9th December 2009

Ref: S6/2009/2047/FP

**RE: ERECTION OF REAR CONSERVATORY AND RETENTION OF EXISTING
OUTBUILDING at OAK COTTAGE RESIDENTIAL HOME 4 WILKINGGREEN LANE
HATFIELD**

Rev	Date	Description	By	Chk
B	20-11-09	Planning comments addressed	SF	SF
Desc:	Conservatory to residential property and shed to serve residential property (Ex. Floor Plans and Elevations)

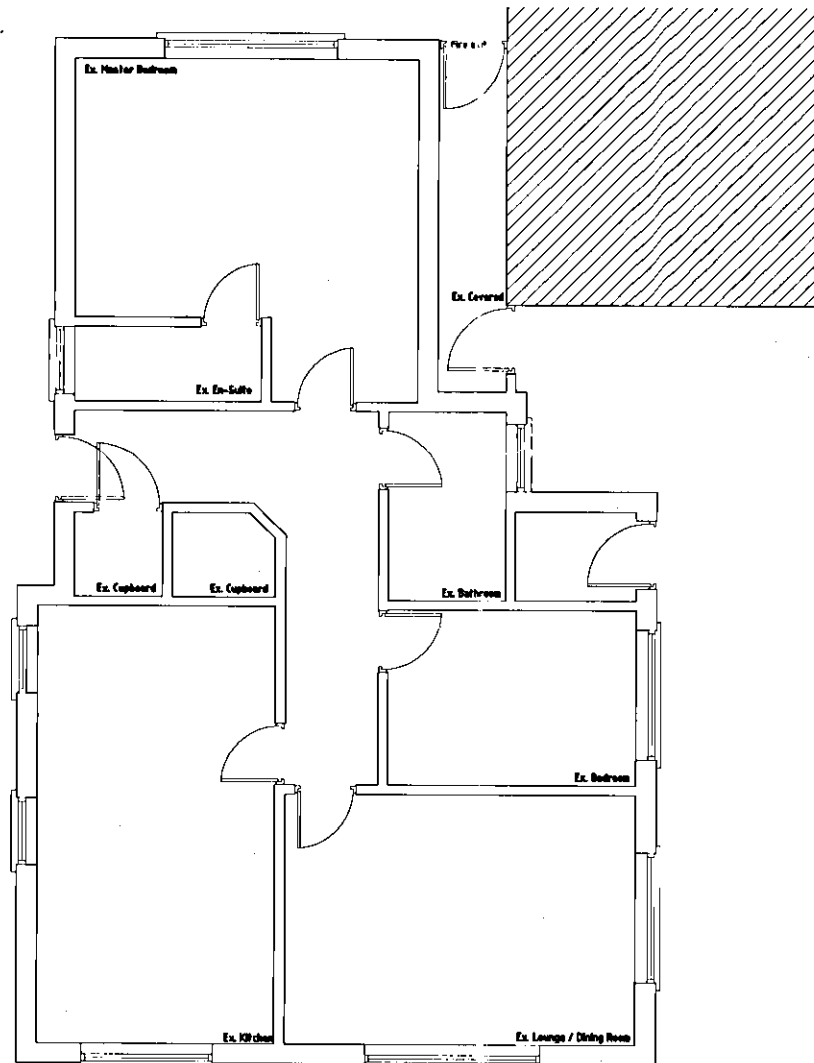
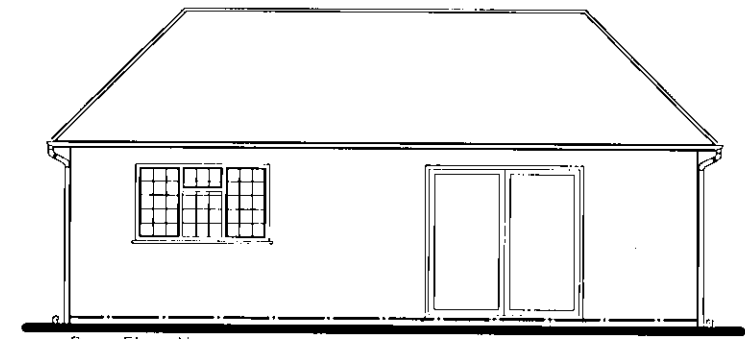
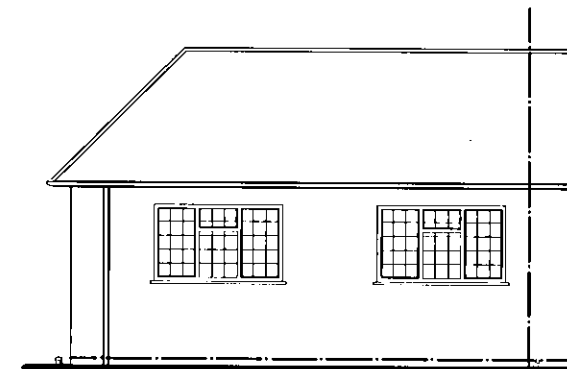
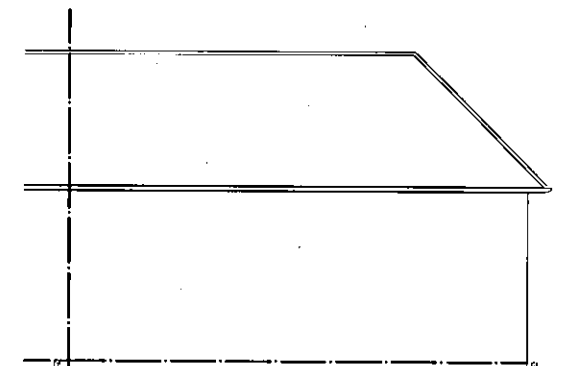
1. We note that the Applicant has proposed to change the style of the roof and that the exterior walls would be timber clad. However, the outbuilding will still be too high and visible. The red tiles will be even more visible from our perspective than formerly proposed due to the "hipped" roof. The outbuilding is still far too close to our boundary i.e. less than 1 metre.
2. We are concerned that in due time the outbuilding will be changed to residential use which goes against the spirit of this application.

We therefore still object to the application on the grounds of height, size and being too close to our boundary.
